Submission on the Environmental Impact Statement (EIS) – Coffs Harbour Bypass

Application No. SSI-7666

The attached feedback is provided as a result of a Coffs Harbour City Council technical review in response to the *Environmental Impact Statement (EIS)* for the Coffs Harbour Bypass, September 2019.

FIG 3.3 VIEWPOINT 2: VIEWSHED ANALYSIS

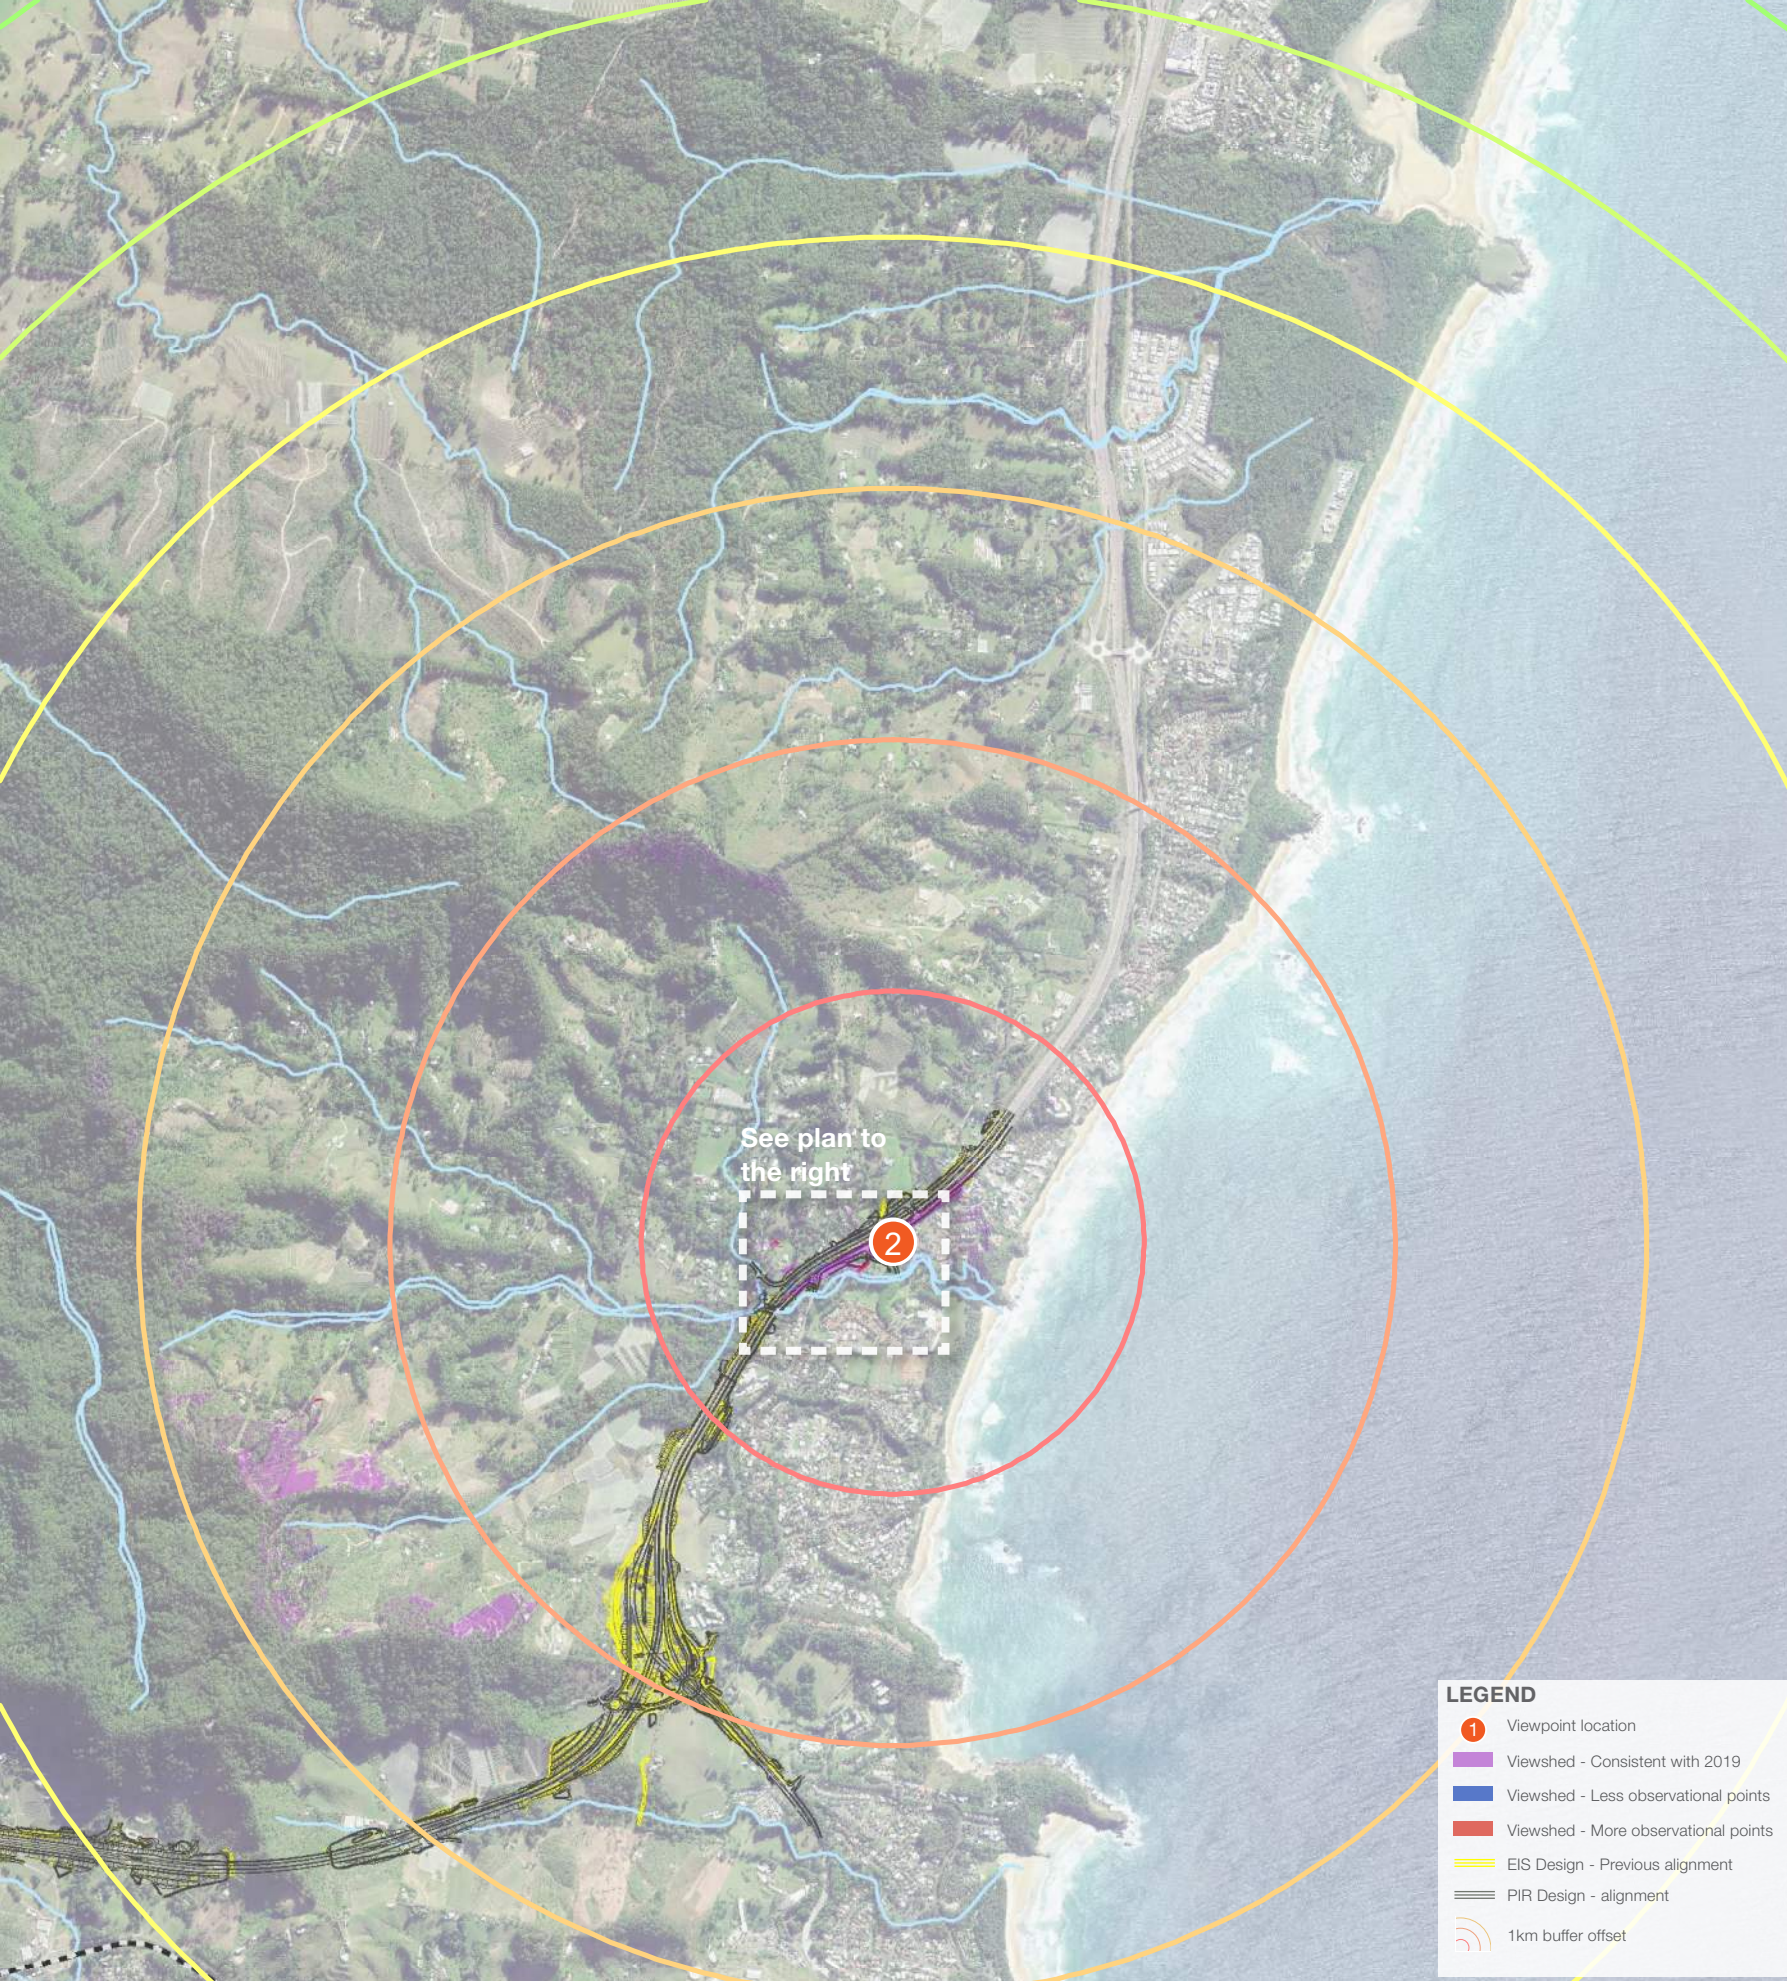
Visual viewpoints created for the project show the project fitting in seamlessly in surrounding areas, which for the most part is true. Viewpoint 2 selected at the entrance to Coachmans Close is noted as having a high magnitude visual disruption. However, there is no enhanced image to show the magnitude of the highway retaining wall in this location. At present the location fronts directly to the existing highway. This will be replaced by a 4-5m high retaining wall + noise screening height.

Additionally, the roadway at Coachmans Close currently has significant screening from dense trees which provides residents a visual screen to the highway and a sense of seclusion.

The intention in this area as far as CHCC can determine from the plan views is that this will be removed to enable the extension of Solitary Islands way and the underpass to the Western Access Road. This will result in views of the 8.3m and 9.0m high retaining walls. RMS note that screen planting will be placed at this location however space appears very constrained and CHCC are concerned vegetation will be omitted.
